CITY OF ALBUQUERQUE

RE: **Lot 4 Block 5, S.A.D. 227**
Unser Cliffs Subdivision
6512 Onyx Ct. NW
Grading and Drainage Plan
Engineers Stamp Date 12-23-19 (E10D071)

MARTINEZ — LOT 4 GRADING & DRAINAGE PLAN

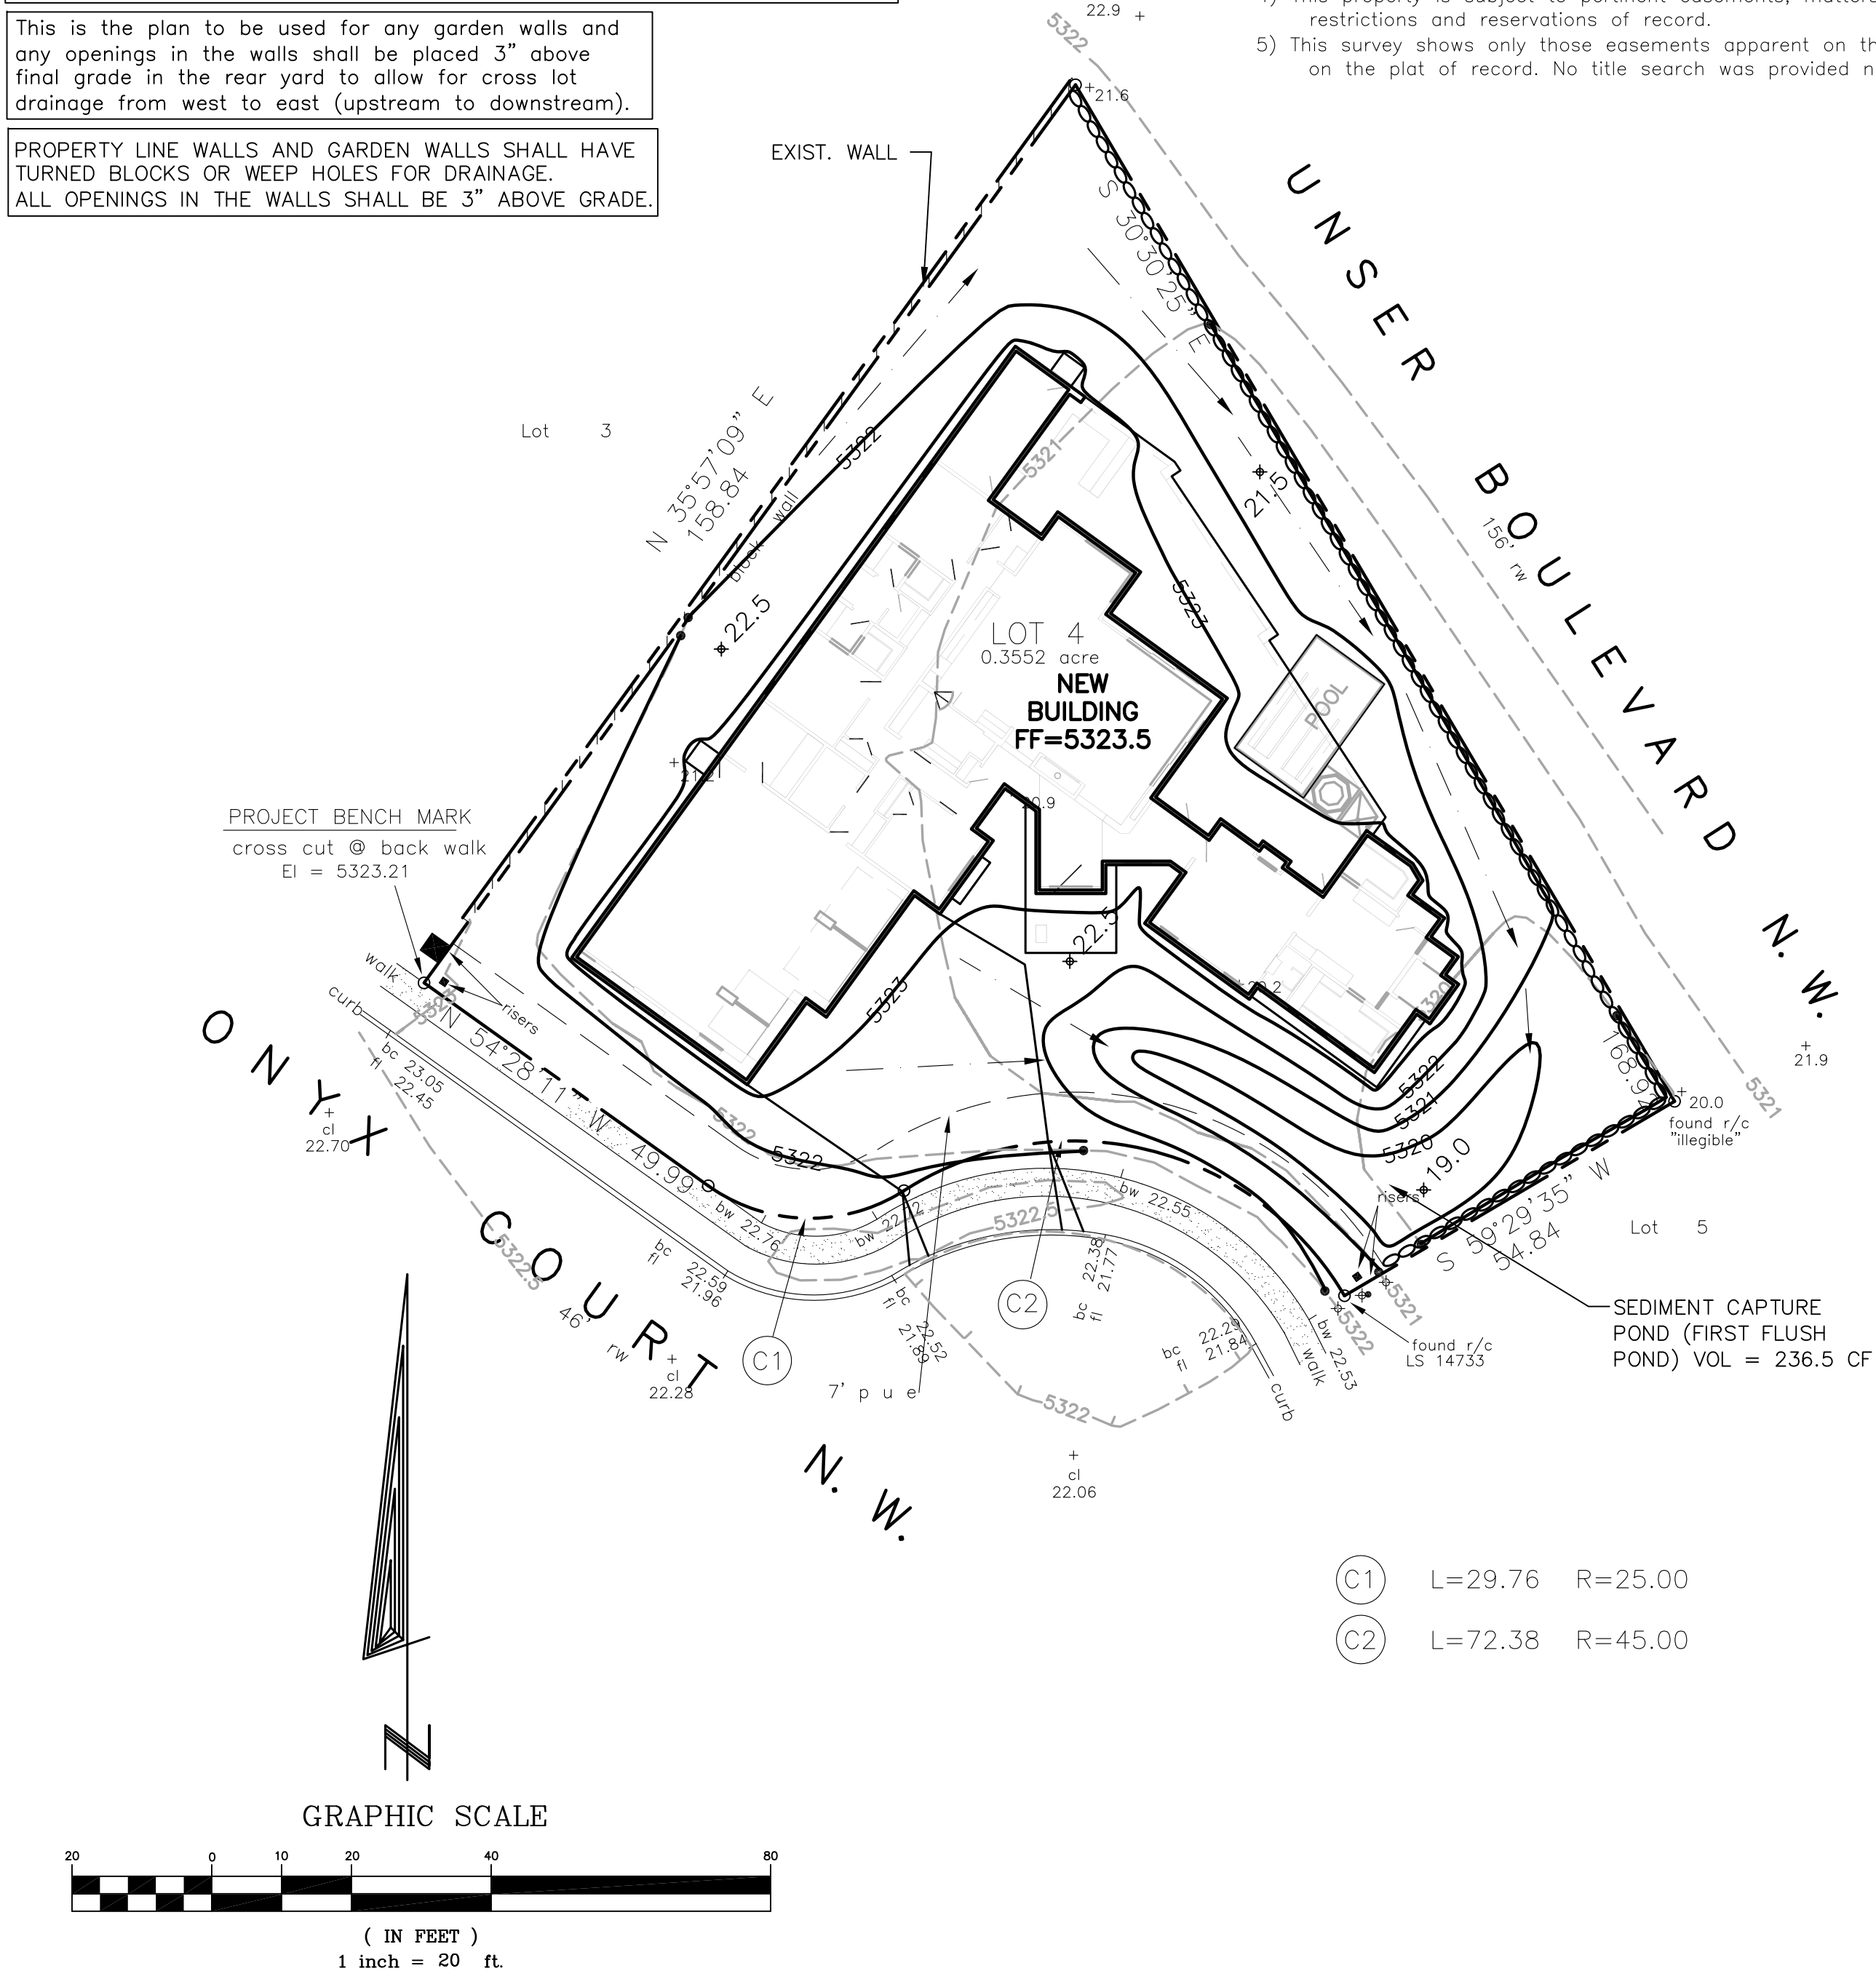
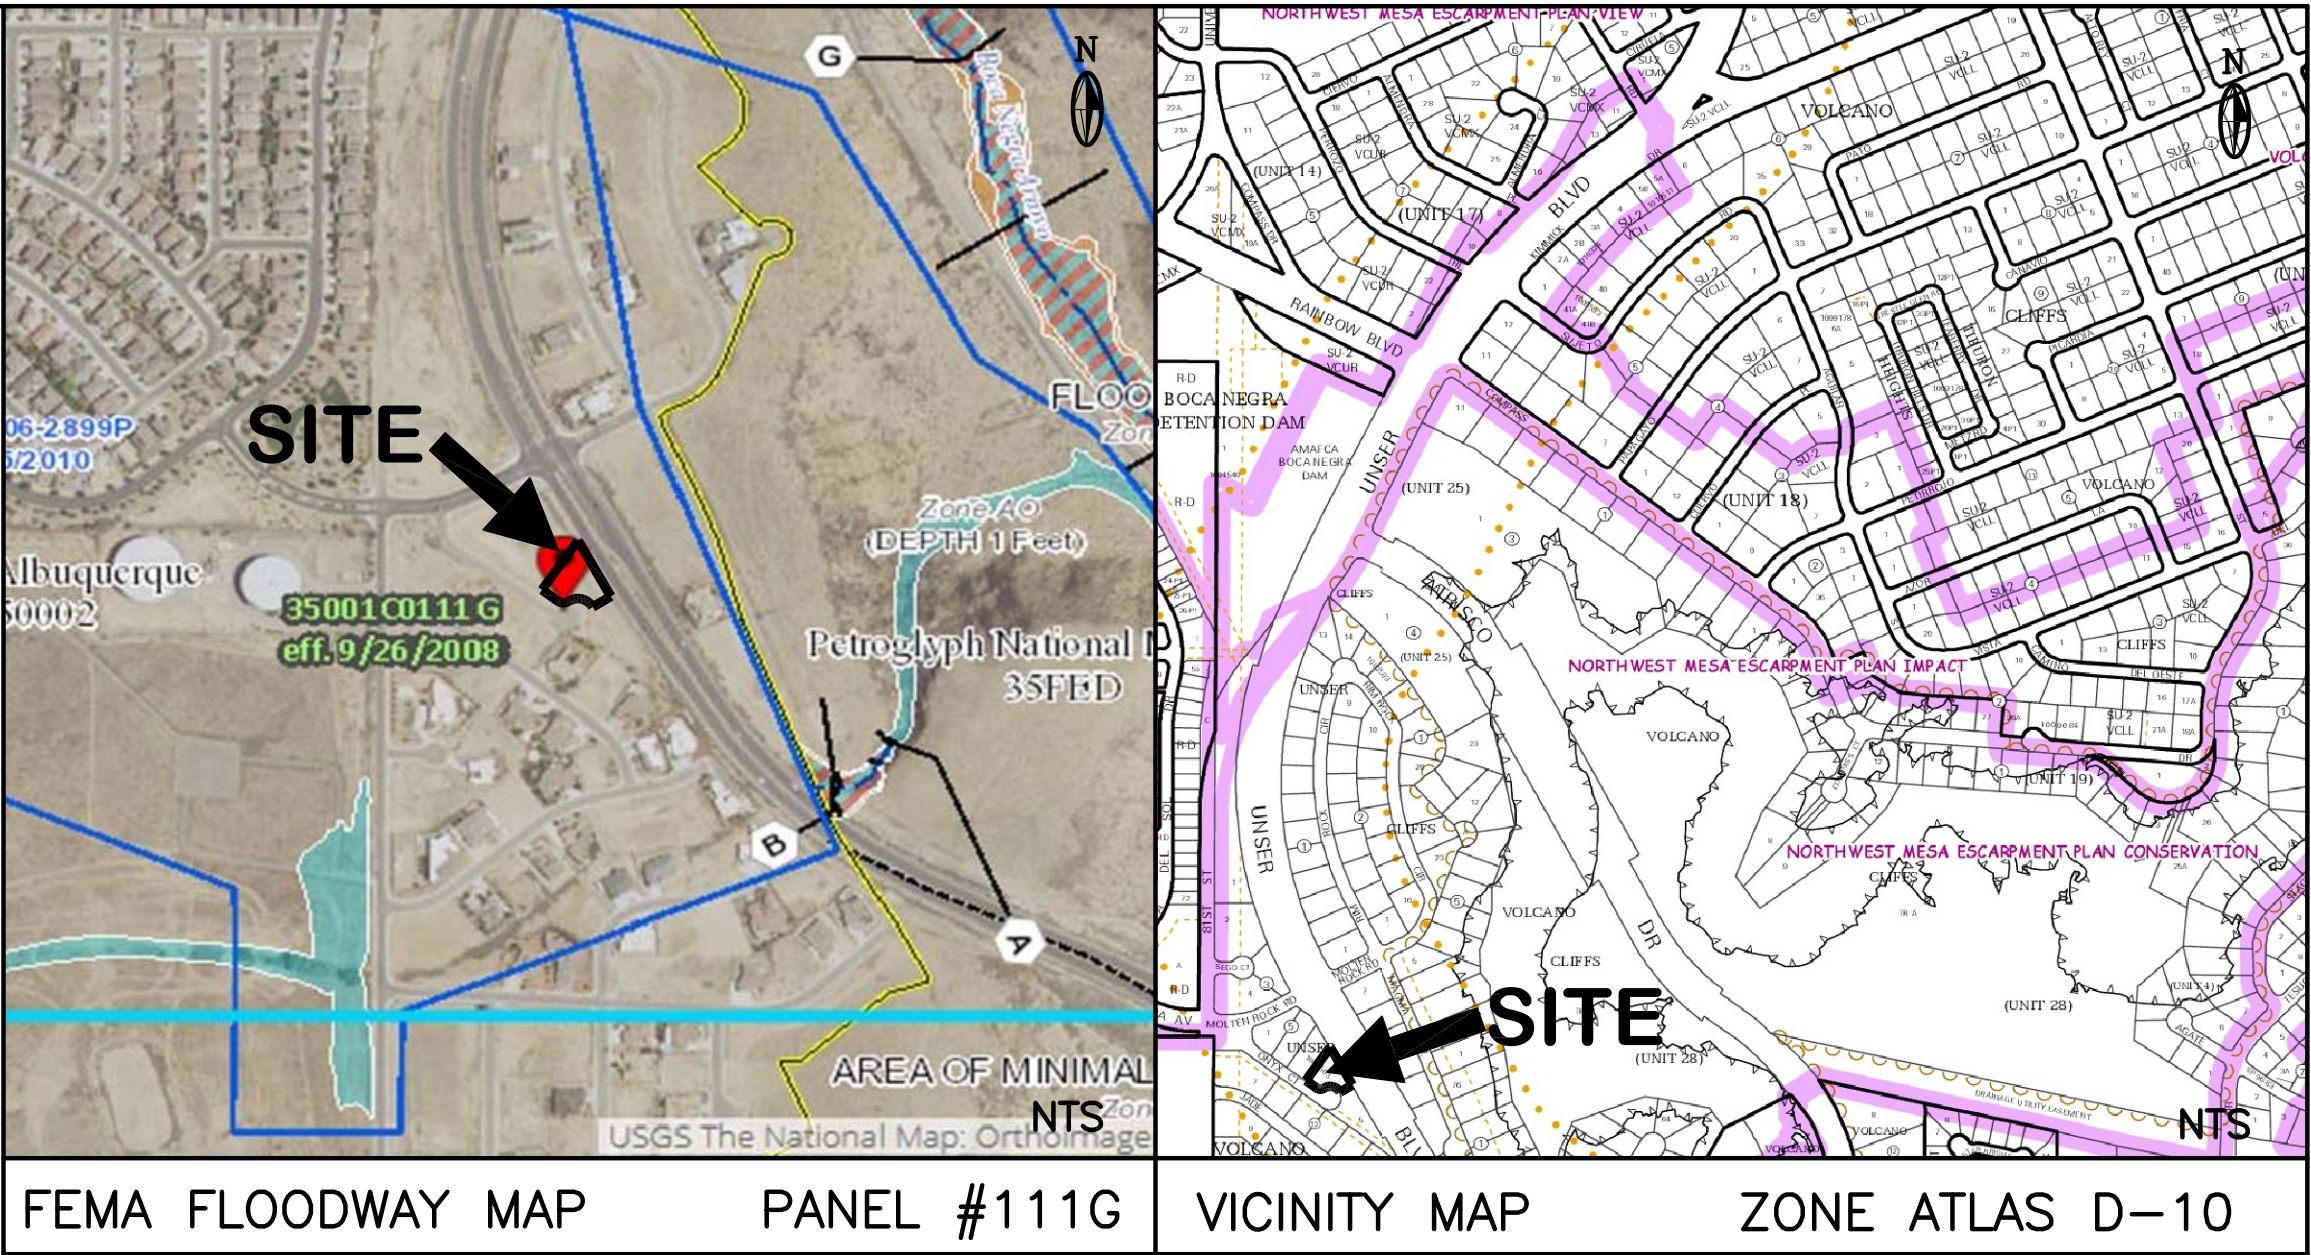
- Direct all flows to exit onto Onyx Ct. through a sediment capture pond.
- Cross lot drainage is not required; remove the turn blocks on the eastern garden wall.
- Provide a percentage for land treatment C.
- Notify the owner/contractor not to use dirt as a ramp to climb the curbing, may use lumber or crusher fines for this function.
